Our ref: Hastings Secondary College Port Macquarie Campus Upgrade-Mod-2 (SSD-11920082-Mod-2)

Subject: Request for Additional Information

PCYC Heritage Impact

4662
DA3011

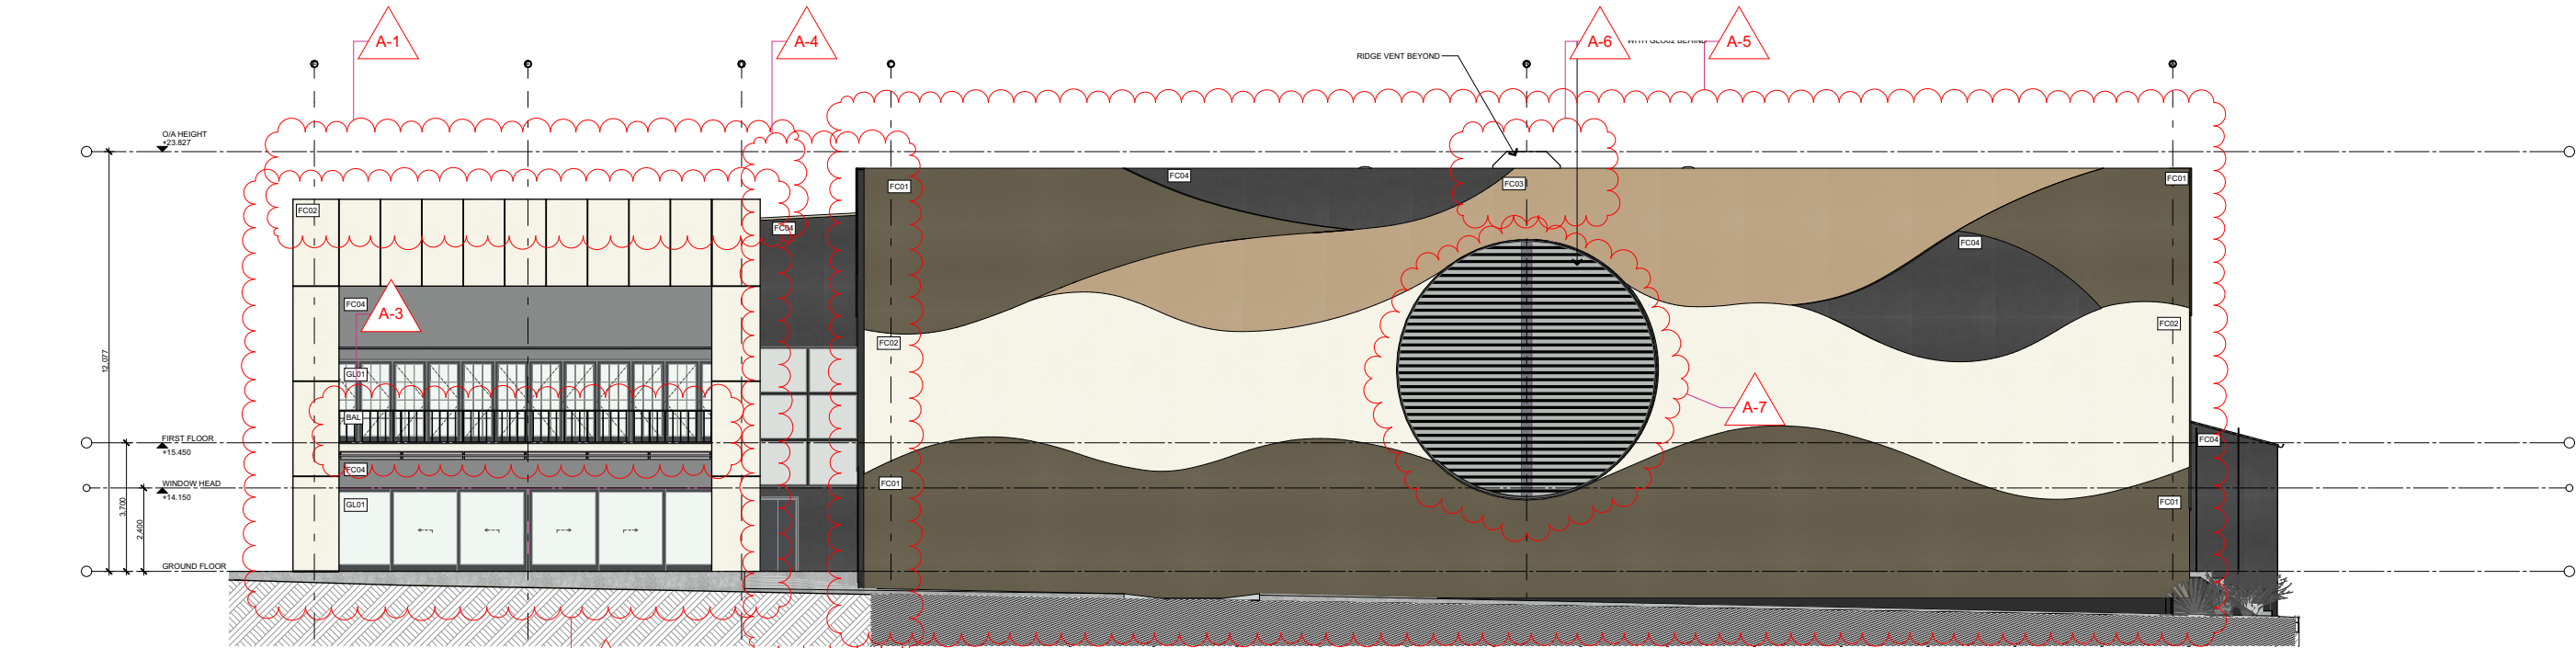
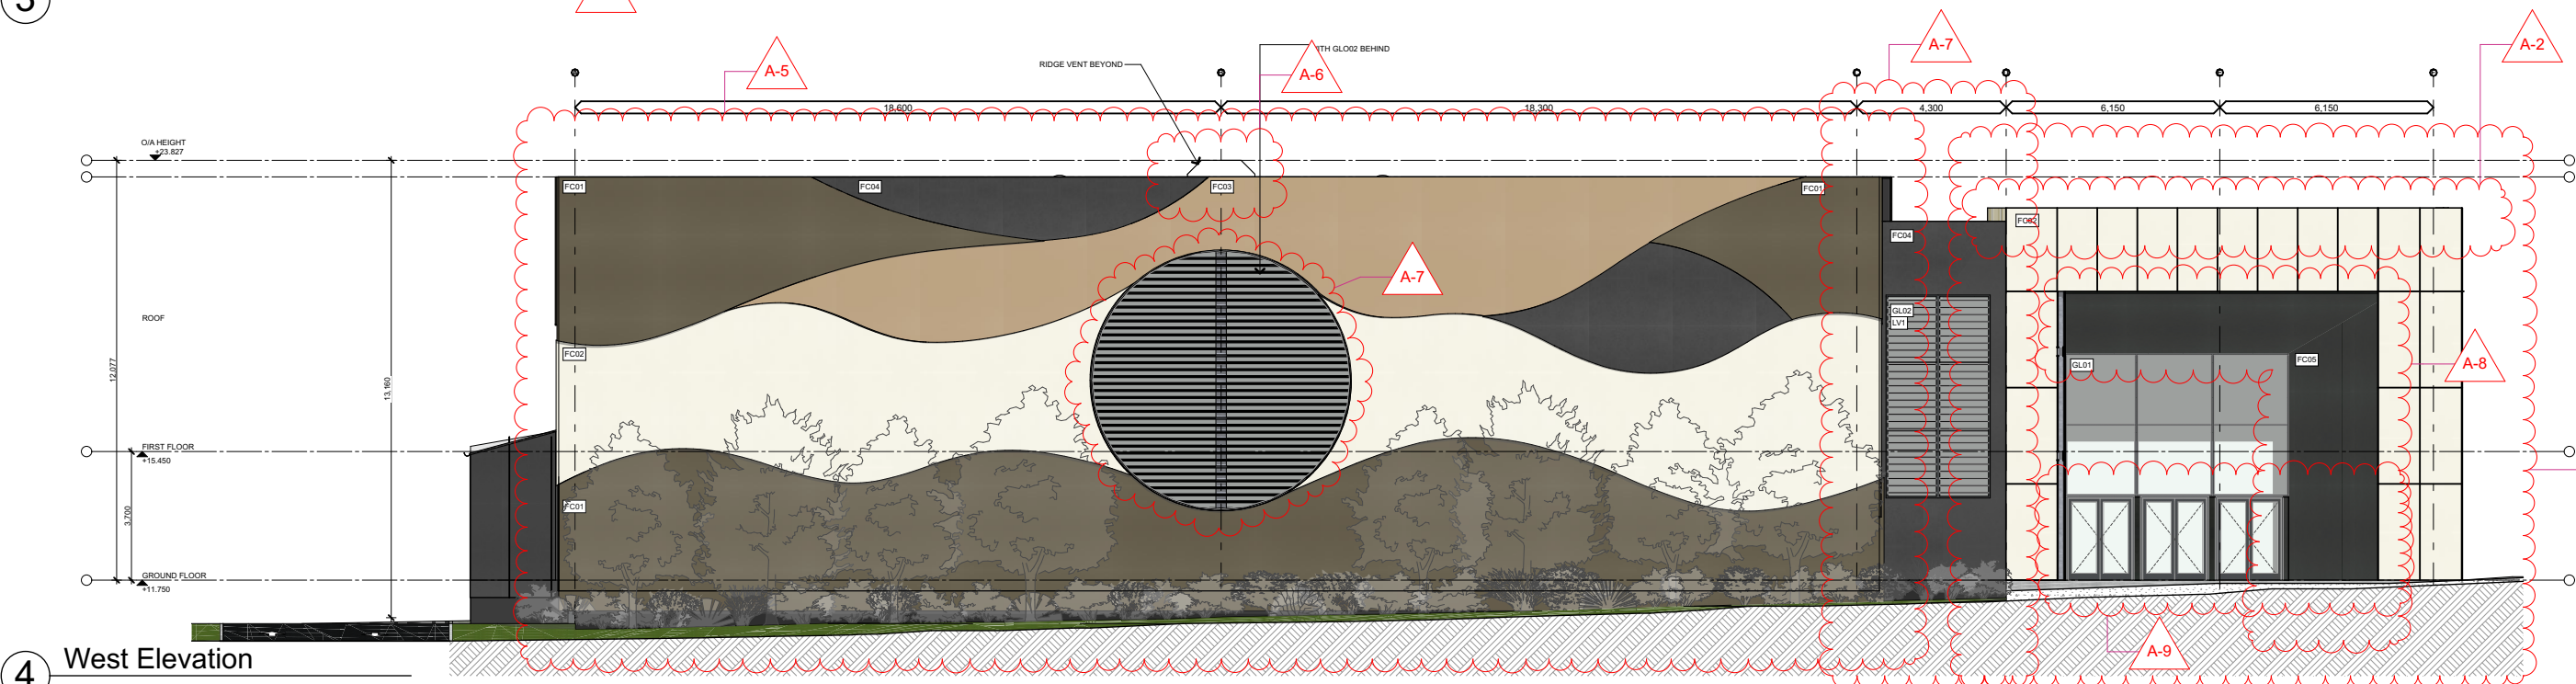
The letter of response to the original RFI, dated 21 December 2022, assessed the proposed changes to the Police Citizens Youth Club (PCYC) façade against the key design principles originally provided by FJMT. However, it has not addressed the heritage impact of the proposed change from brickwork to fibre cement sheeting. The original Statement of Heritage Impact noted that the 1960's campus has an established language of two-story, face brick buildings, which the new masterplan will respect and respond to. As there have been changes to the materiality of the building, the HIS will need to be amended to reflect changes to the Heritage Impact.

- An amended HIS (undertaken by a suitably qualified person) addressing matters related to the proposed new materiality of the PCYC building and associated heritage impacts.
- Alternatively, the architectural plans should be amended to revert to the approved materiality considered in the original HIS.
